Permit Number: 030263

This is to certify that Dictar Associates Ii/Acero Design
has permission to Build new exterior stairway
AT 468 Fore St L 038 F008001

Proposed Use: Hair Salon/Spa with new exterior stairway	Proposed Project Description: Build new exterior stairway
---	---

STAIR PLAN - FRAMING PLAN

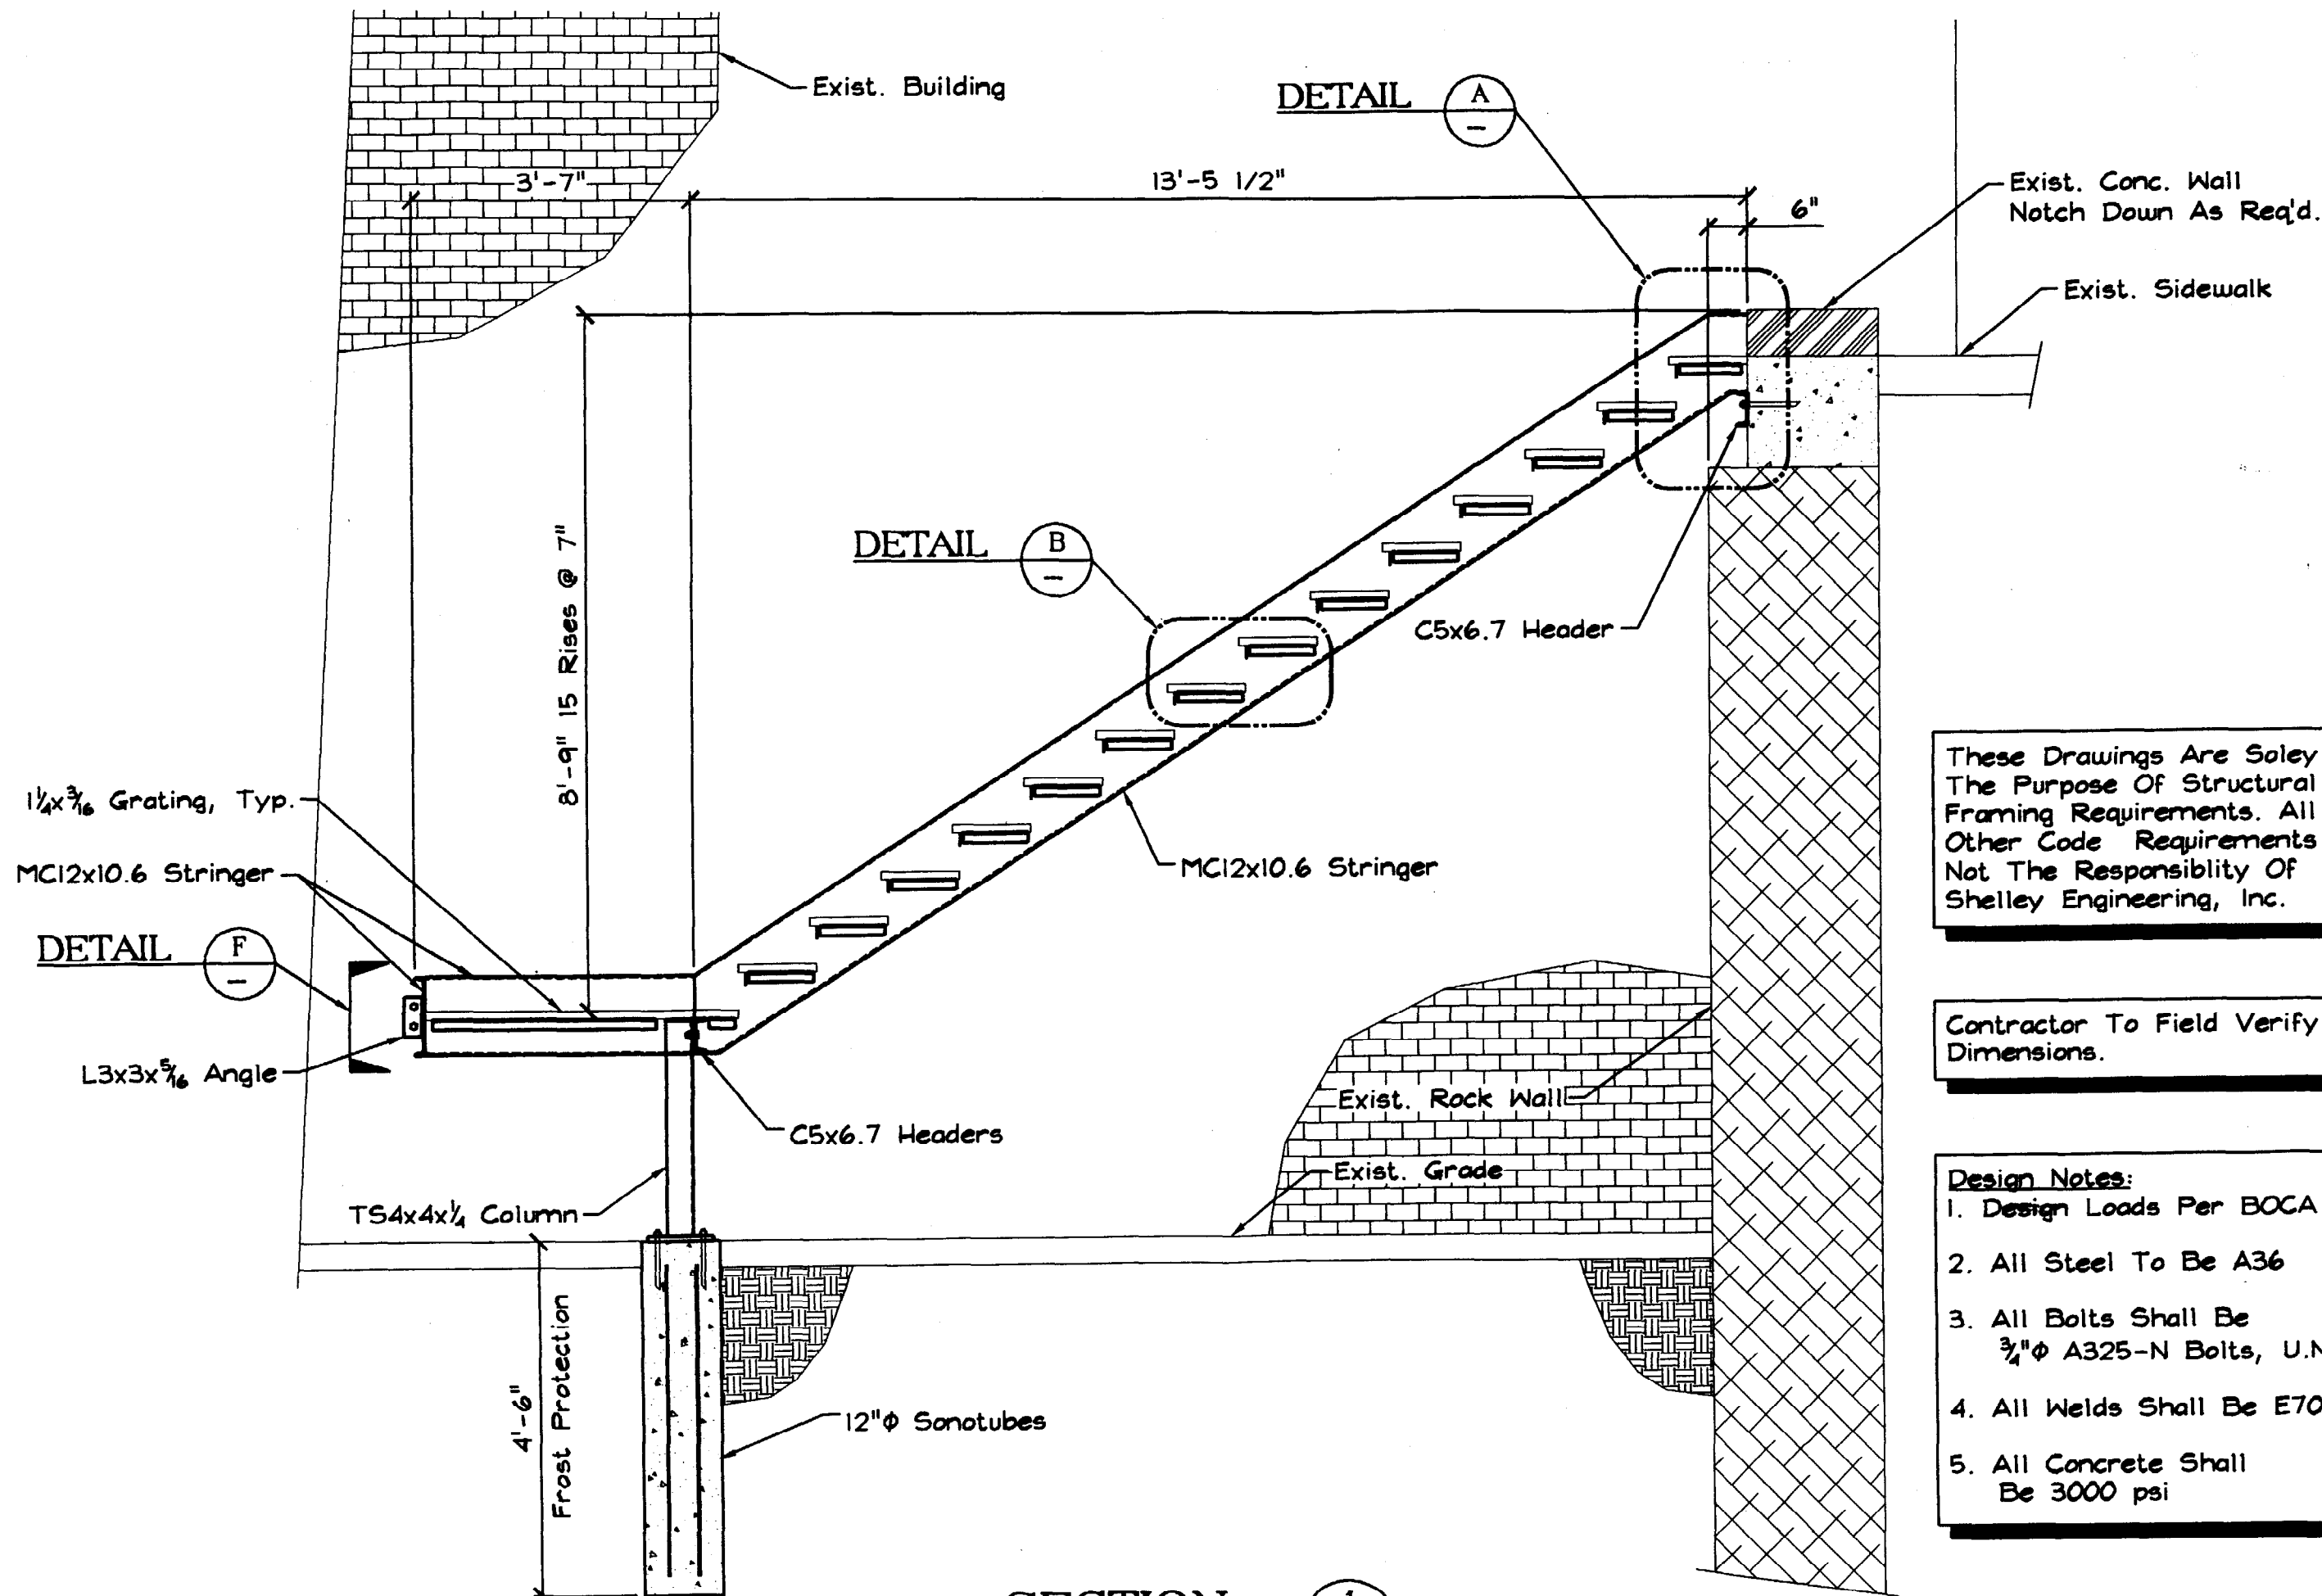
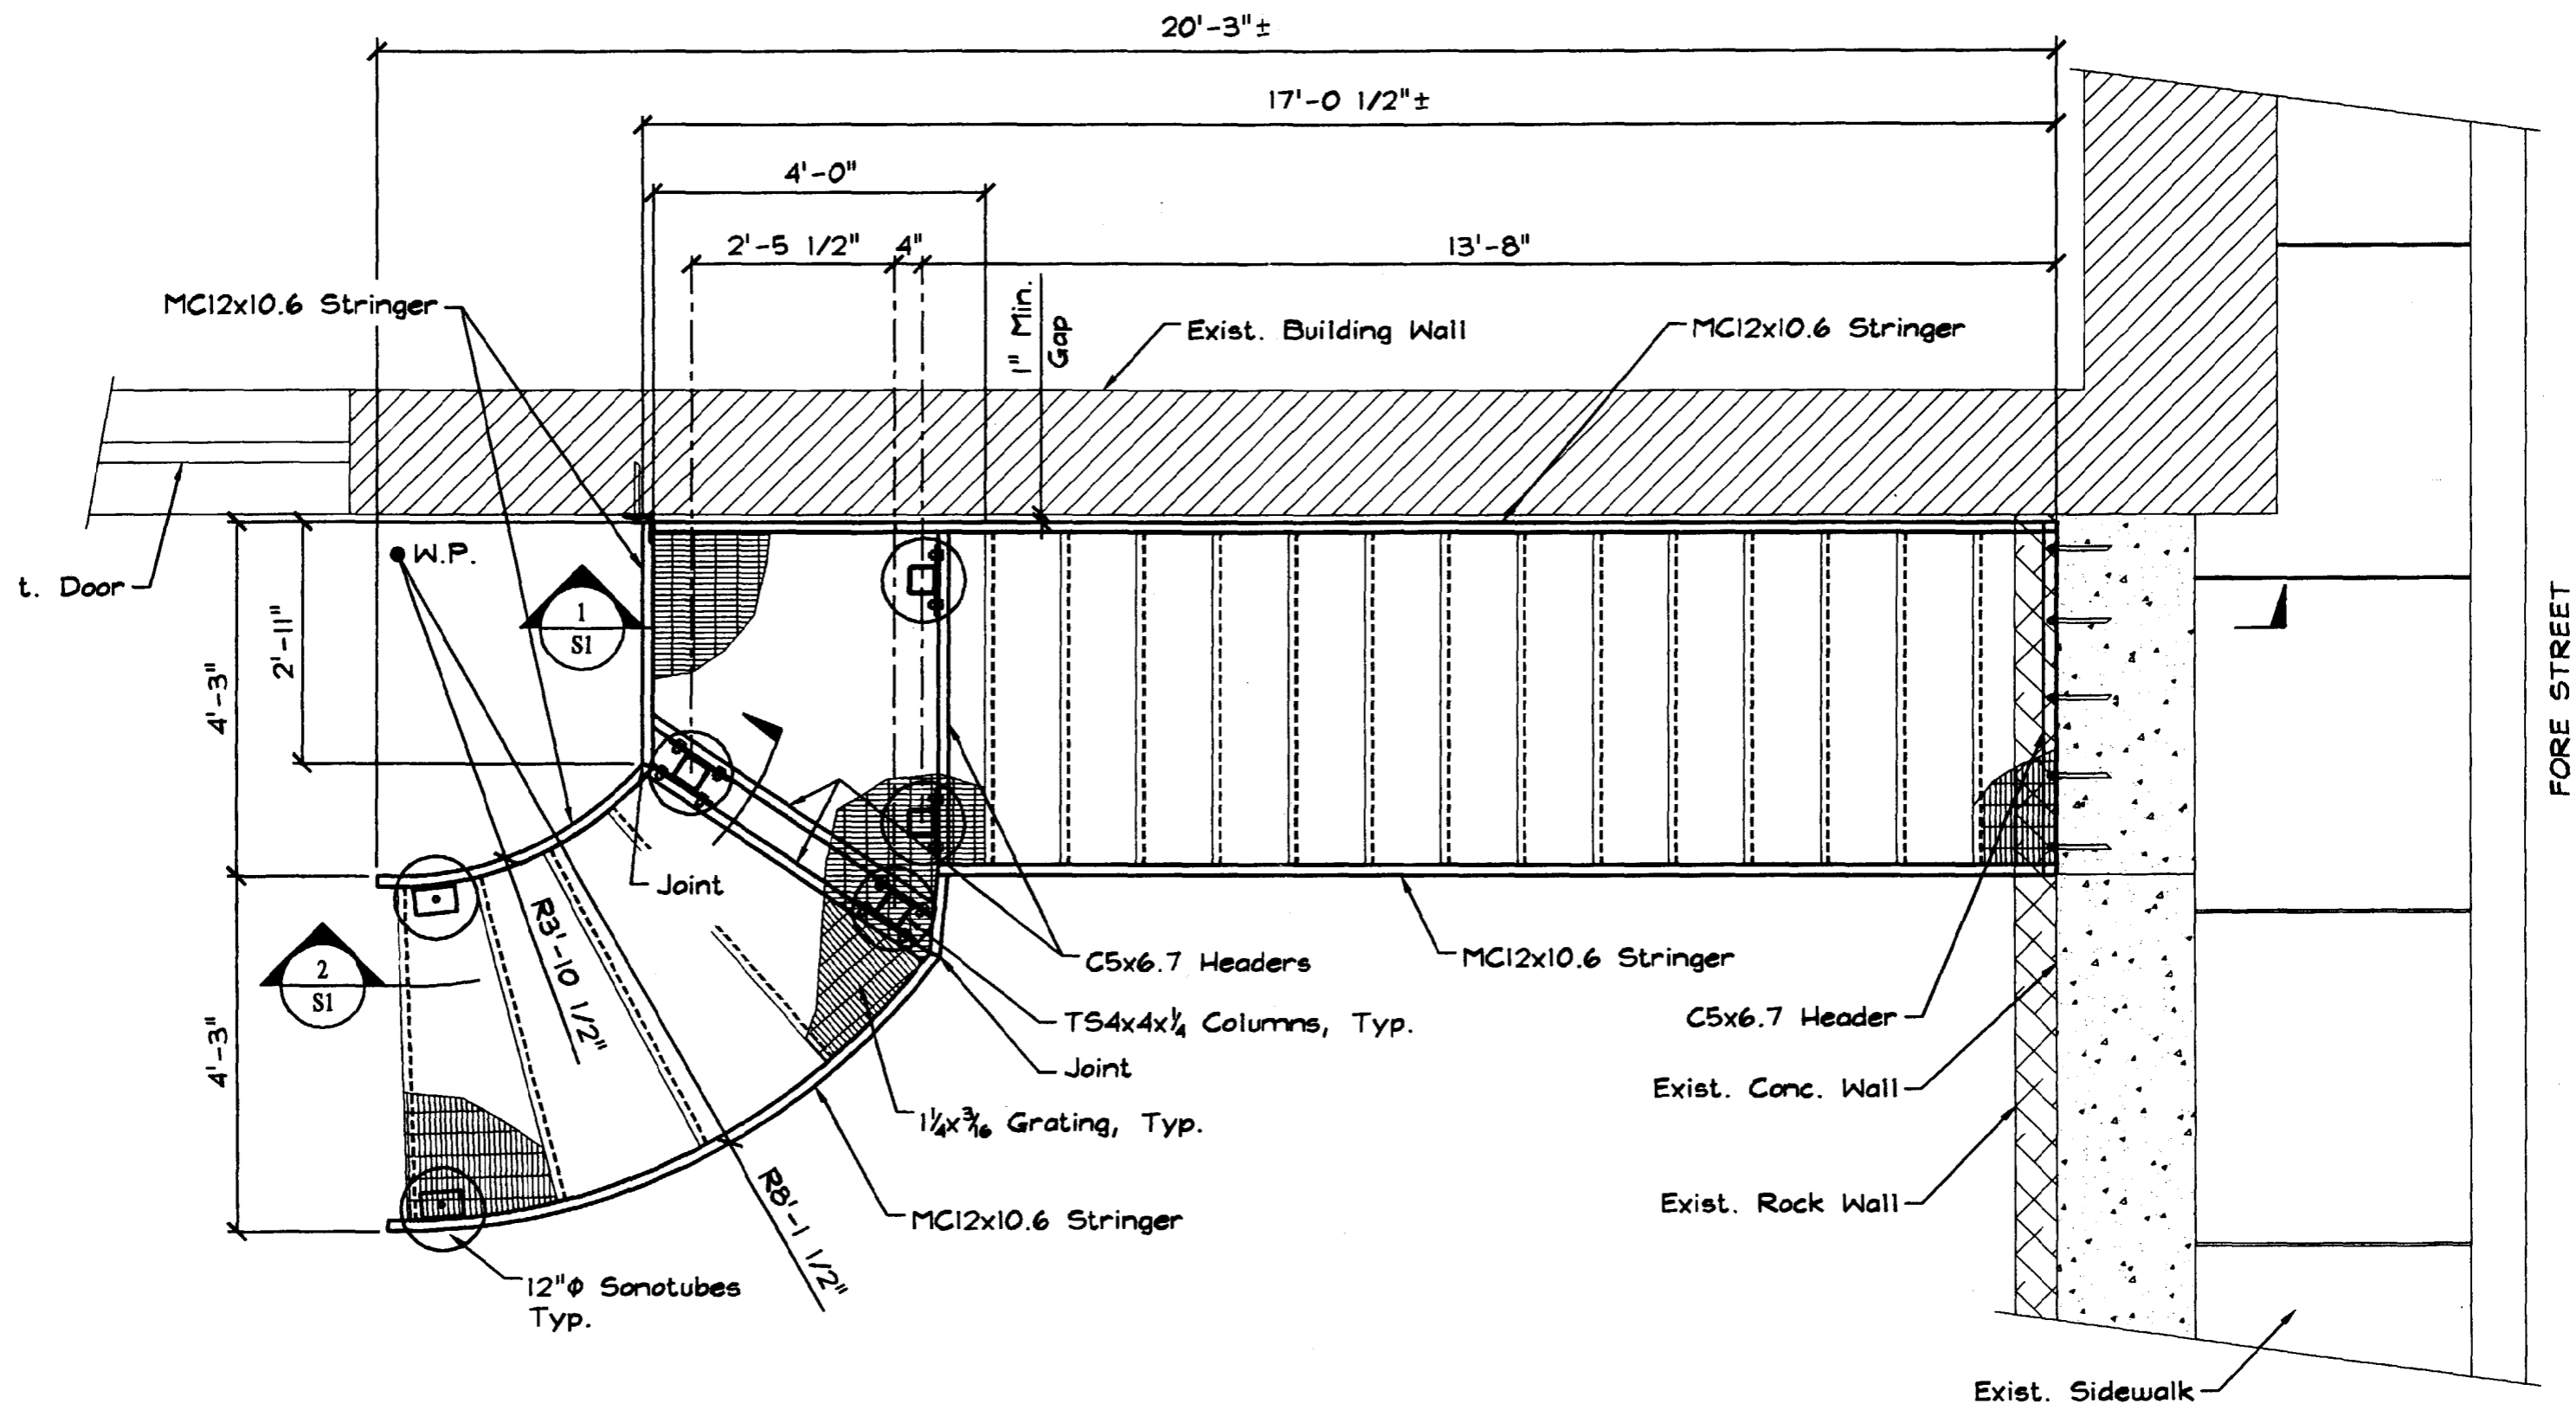
Note: open risers shown, and need more info on how it attaches to building. **Ok to Issue:**
Ok to issue - resolved issues

1) Guardrails MUST be a minimum of 42" measured from the leading edge of the tread as discussed.

Dept: Building **Status:** Pending **Reviewer:** Tammy Munson **Approval Date:**
Note: HOLD- open risers shown, and need more info on how it attaches to building. **Ok to Issue:**
